PE TEAGUE, PE, PLLC
2705 Waterloo Court, Raleigh, NC 27613
(919)247-2572, peteague50@gmail.com

July 21, 2023

RE: Engineering - Plan Review and Structural Recommendations
MIKE SAYRE PLAN
Project No.: 23PT-0620A

REAR ELEVATION

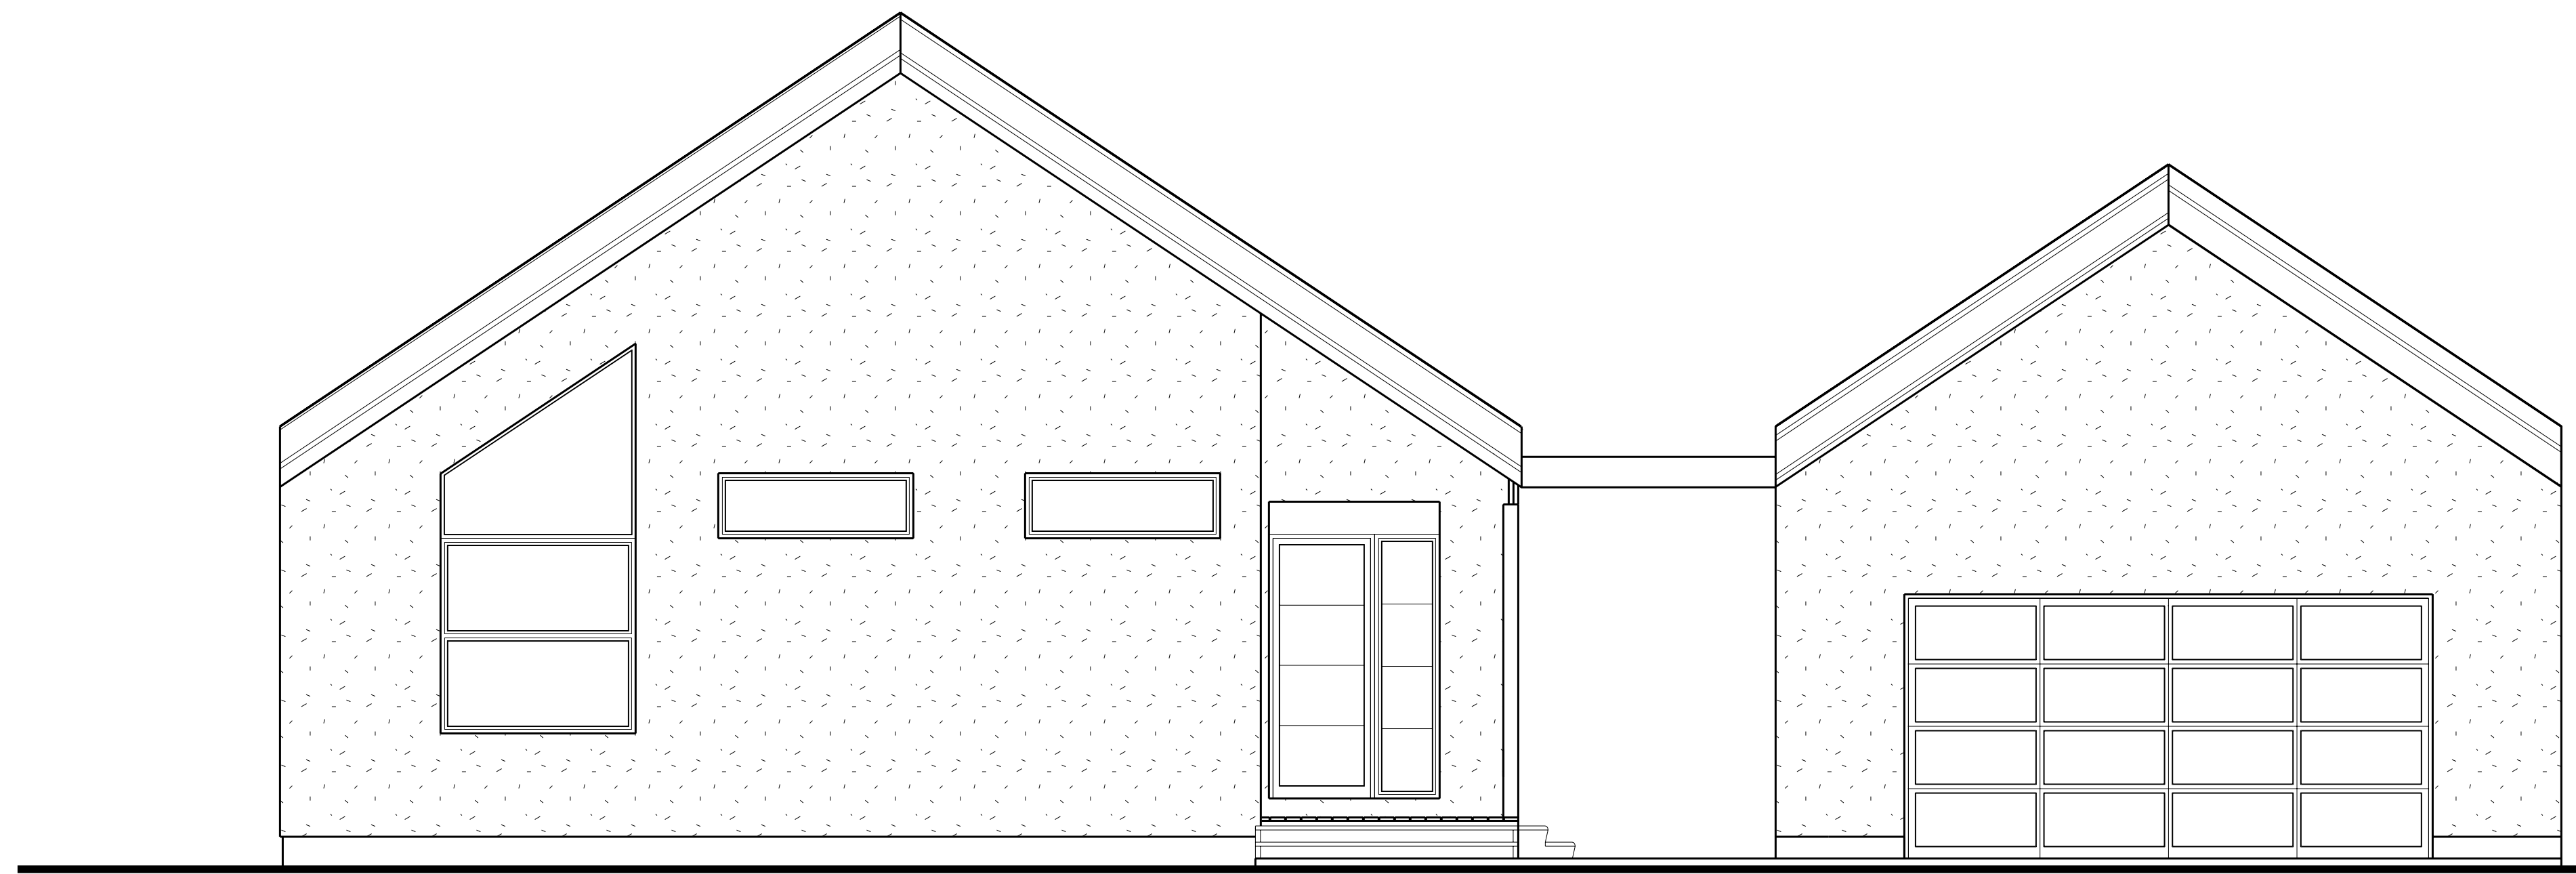
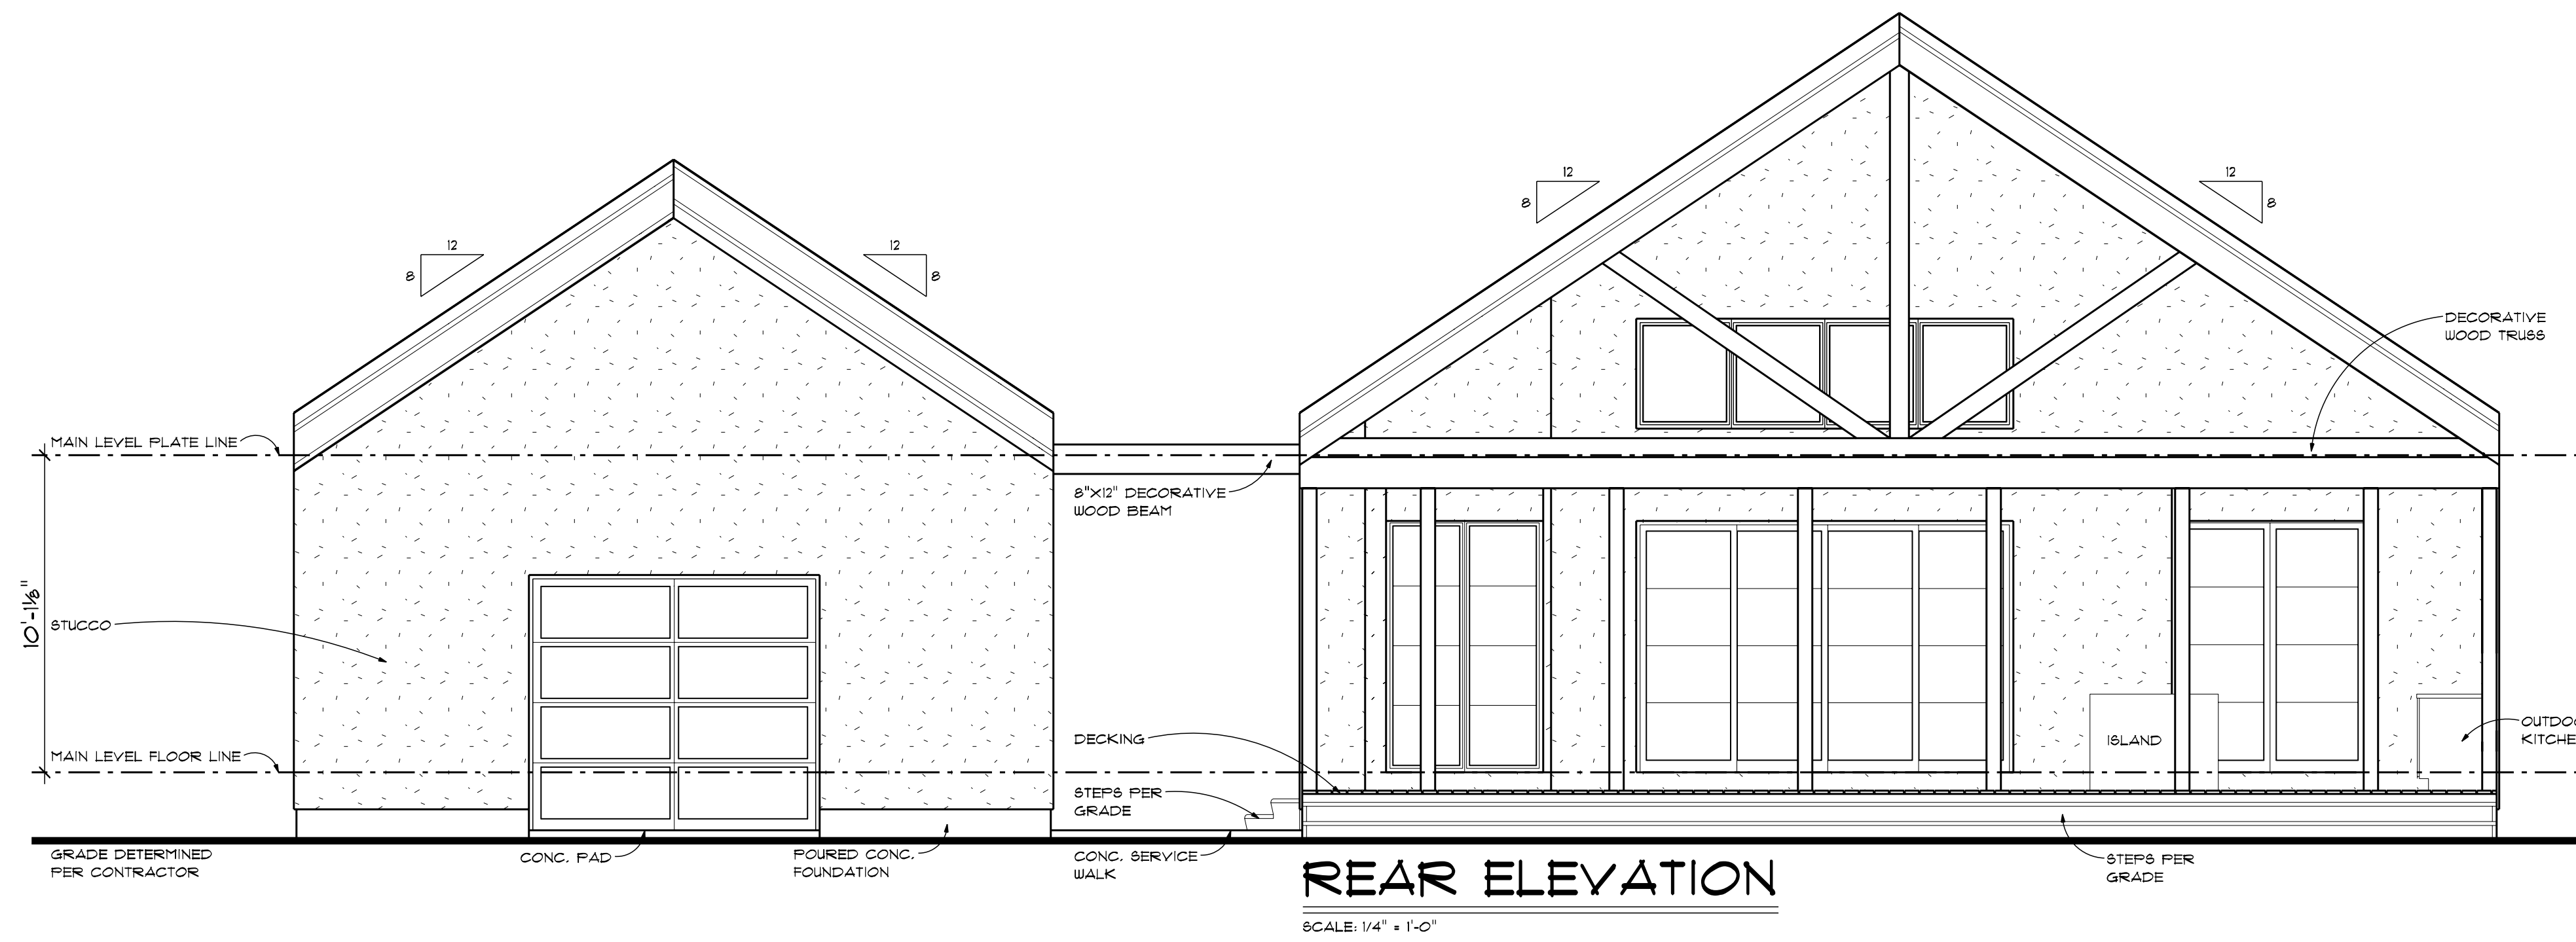
Brace walls for continuously structurally sheathed conditions are adequate with the following exceptions. The front garage wall and the rear wall for the main structure as shown on sheets 2 and 3 of 8 29955. These walls require portal framing in accordance with R602 of the NCSRBC. The headers across the walls should be (2)1.75X11-7/8 LVL's running across the entire walls in accordance with R602 of the NCSRBC. The walls will be required to have a Simpson H2.5 attached to the roof trusses to the top plate for the main structure as well as the rafters (use of conventional framing for the garage - changed from the roof trusses). The porch framing on the exterior require the beams to be treated SYP (4)2X12's spanning no greater than 7ft 2in in the clear and should be posted to a treated SYP 6X6 to be attached to the beams by a Simpson EPC6Z post cap and to the concrete footing by a Simpson ABA66Z post base. The posts should run from the bottom of the beam to the footing. This may require the floor bands to be through bolted to the posts with two 5/8" diameter bolts. The porch post footings will require a 18"x18"x18" concrete for each post. The foundation walls should have 8 inch CMU foundation walls on a 10" thick by 18" wide concrete footing with two # 4 reinforcing steel bars continuously. The walls should have 5/8" diameter foundation bolts 1 ft from each corner and every 6 ft c/c with the exception of the two portal frame walls outlined previously. The exterior porch bands and floor joists appear to be adequate for treated SYP framing members as shown on the plans as shown on sheets 4 and 5 of 8 22915.

TYP. GARAGE WALL

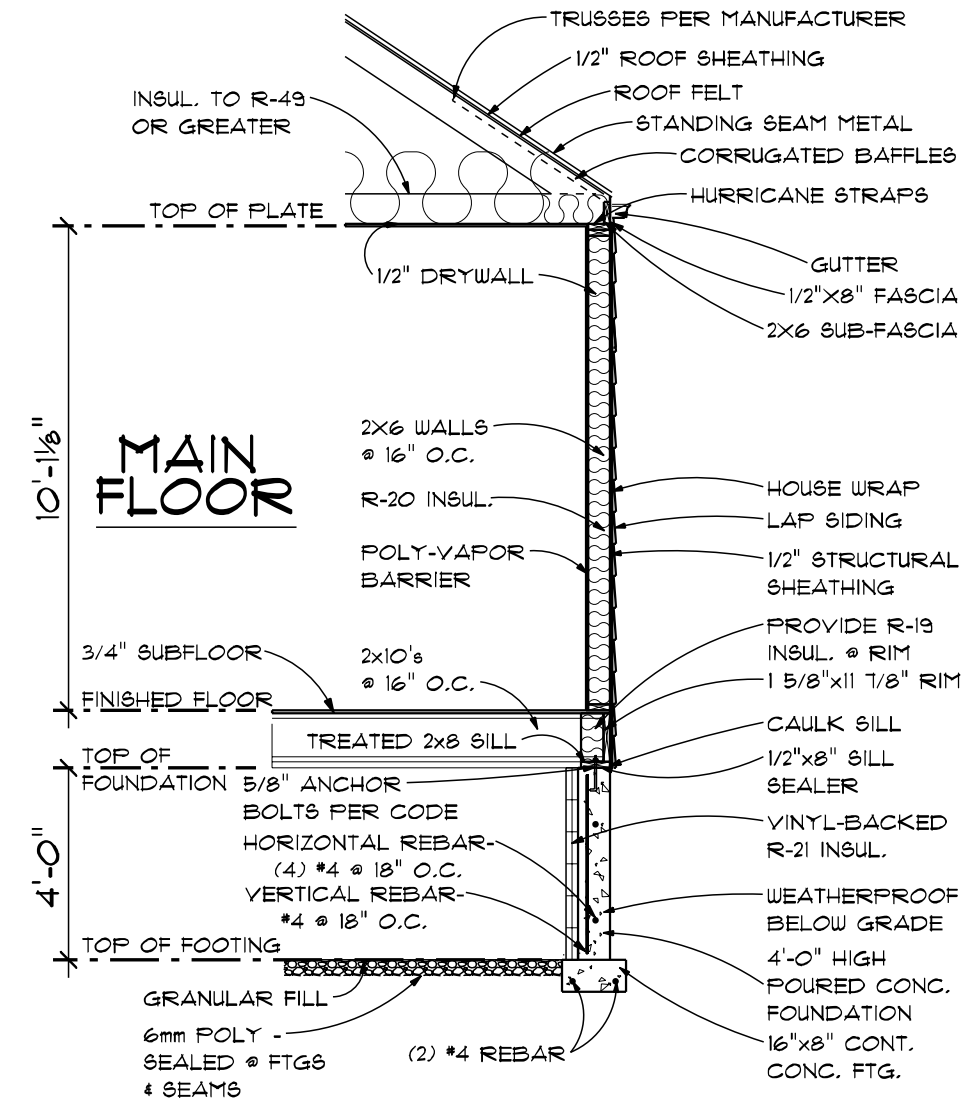
The garage roof and ceiling joists are planned on being conventionally framed by using 2x8 rafters at 16" c/c with a 2X6 collar tie every rafter at 1/3 the ridge height and a 2X10 ridge board. The ceiling joist will require an I-joist every 16" c/c. The I joist spanning 24 feet left to right (BCI 60s 2.0 or equivalent) would need to be a 11-7/8 inch deep joist for ceiling load only or a 14 inch deep joist for floor (40 PSF LL).
